From: Tim Screen
Sent: 23 November 2021 12:02
To: Rebekah Morgan
Subject: 21/03343/F - Land Adj To Promised Land Farm, Wendlebury Road, Chesterton

PROPOSED SURFACING & LANDSCAPE PLAN

PLANNING David Lloyd CLUBS. CLIENT: CATALYST BICESTER. PROJECT: PROPOSED SURFACING & LANDSCAPE PLAN. DRAWING: TH, DATE: SEPT 2021. SCALE: 1:250 @ A1.

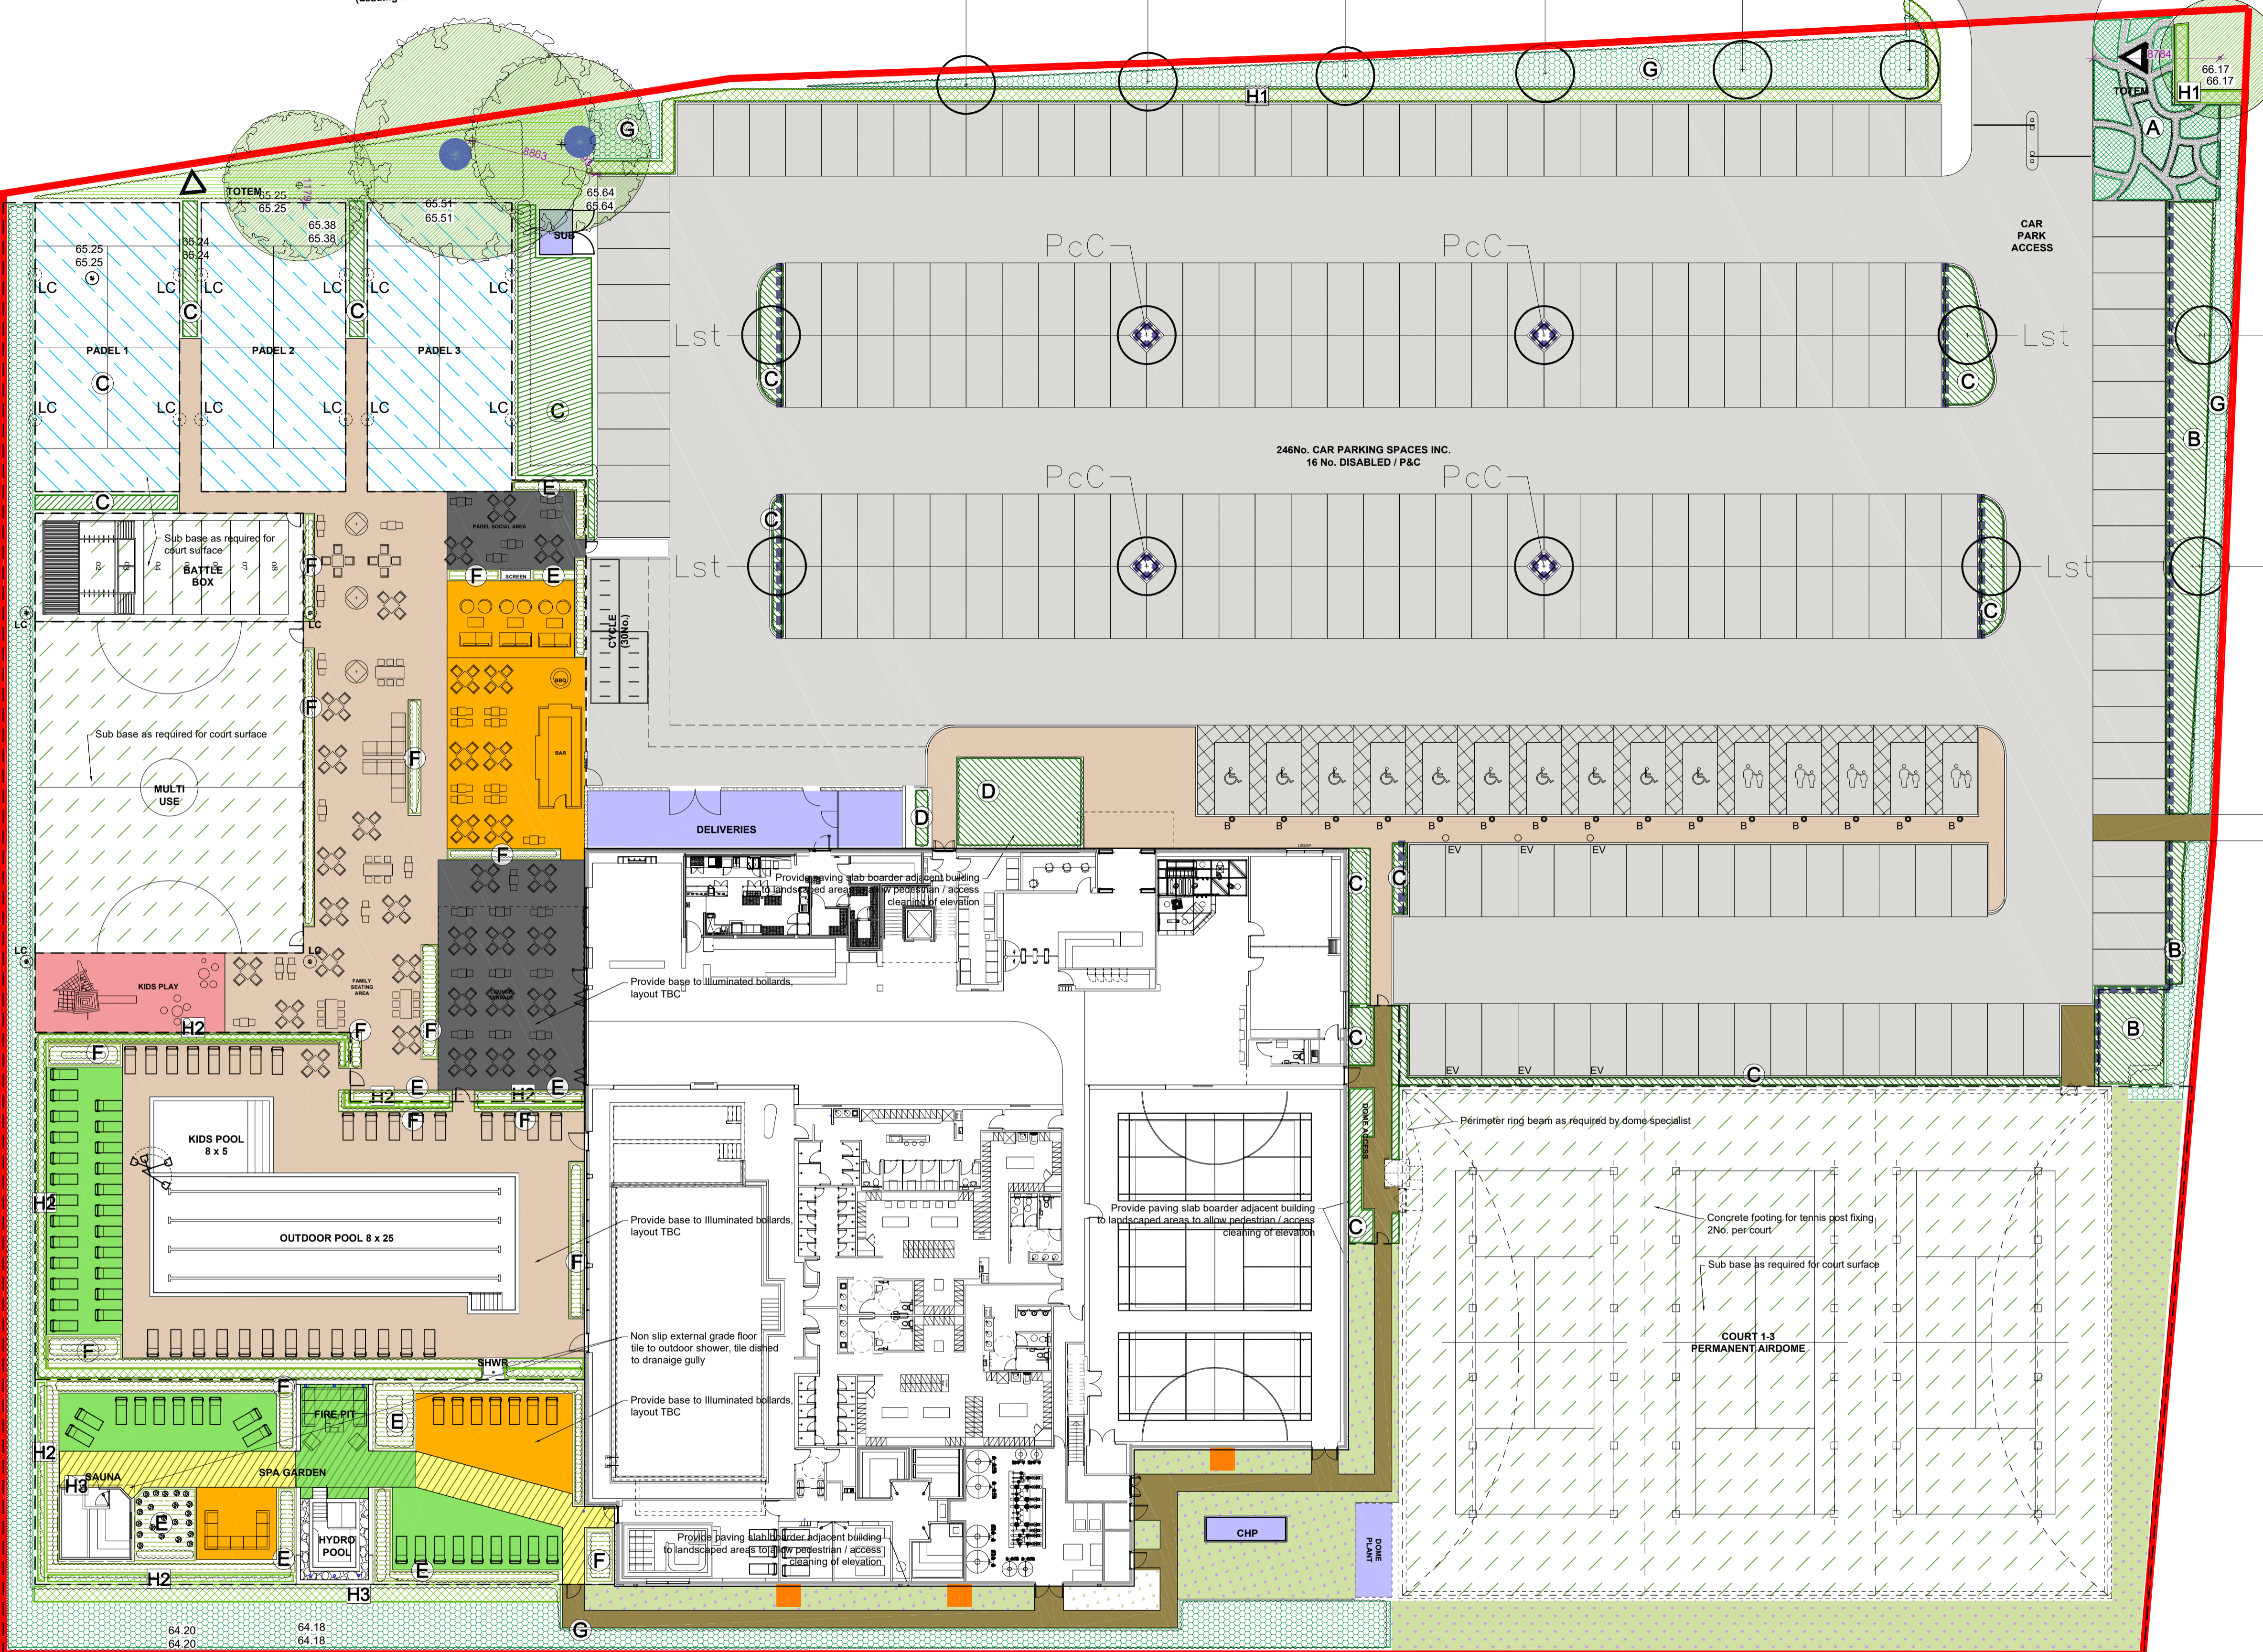
A substantial amount of native structural vegetation has been removed from the frontage of Wendlebury Road for the benefit of highway vis play, roundabout and road realignment and widening. This has exposed the site where visual receptors experience harmful construction impacts, operational and physical impacts of large car park and buildings where once there was an attractive country lane. The proposed *Fagus sylvatica* hedge is too formal and does not have the species (flora and fauna) diversity and visual richness of a native mixed hedgerow, which is required here - not forgetting an improved BREEAM score for the overall development. The mixed native hedgerow will require a 1 m wide wildflower verges on both north and south sides; against the pedestrian route and the car park to allow for the growth of the hedgerow. The regimented row of trees is too formal and irregular spaced native trees in groups are required. The hedgerow should be implemented at the earliest opportunity during the current planting season with appropriate landscape maintenance to aid its establishment and facilitate growth, whilst site clearance and construction proceeds. This will provide some visual benefit, but also reassurances that the construction/operational and visual impacts are being addressed at the earliest opportunity.

The potential 'heat island' effect and the harmful visual impact of such a large car park must be addressed for the benefit of onsite users. Additional, climate enhancing, trees should be planted in the car park where space, services and parking bay numbers allow. It has been established that groups of trees sharing the same larger volume tree pit establish and perform better than single trees in isolated tree pits. I would prefer to see larger tree'ed areas protected by knee rail and understory planting. All trees are to be supplied, handling, planted and established in accordance with the current British Standard BS 8545: 2014 The *Pyrus calleryana* 'Chanticleer' are generally ubiquitous; they are prone to ugly, wound healing deformations to the main stem. Therefore replace this cultivar with *Ginkgo biloba* trees with the more attractive bark. Tree pit details are going to be necessary. Root barriers should be considered and their positions indicated on the landscape proposals.

The proposed trees for open space and street should be appropriate in terms of 'Right Tree Right Place' and I therefore recommend that the landscape consultant to consider TDAG's tree species selection for green infrastructure at the earliest opportunity. Are revised layout should accommodate more street trees to be adopted and maintained by OCC.

The planting distances are incorrect and planting density should be increased for most species. Good ground coverage is required after 2-3 growing seasons. For example the *Potentilla fruticosa* 'Abbotswood' is proposed to be planted at 0.71 m apart which is far too open. I recommend 3 P.f 'Abbotswood' plants per sq. m to achieve the desired effect. All plant densities should be looked at again and the nos/sq. m rule imposed.

There is no instruction to plant in species groups or drifts of 3, 5 or 7. This appears to be left to the landscape contractor during site operations. There is even no instruction to ensure the species are not planted too close to the edge of borders. This may happen, whereas species grow over the path they will be unsympathetically pruned.

Plant bed C border between the car park the dome is too narrow for effective establishment of plant species, and will be overshadowed by the dome. There will be insufficient topsoil and drainage because the concrete haunching to retain the edge of the paving and playing surface will be very substantial. Delete this border and replace with free-draining gravel surface. The dome and the adjoining car park are visually onerous and tree planting in the car parking is appropriate to visually mitigate these elements.

The Landscape Management notes on the drawing are limited in their explanations and must be confused with the more detailed LEMP. These notes should therefore be deleted off the drawing. Shrubs should be pruned at the correct times to enhance flowering and the production of fruits for visual appeal and food source for birds. For the proposed trees there should be inspections, hand weeding, mulching, stake and tie adjustment, formative pruning and ground moisture monitoring and watering at appropriate times, all in accordance with BS 8545. It should also mention that dead, dying and diseased trees are to be replaced.

Revised landscape proposals are required along with tree pit details/specifications.
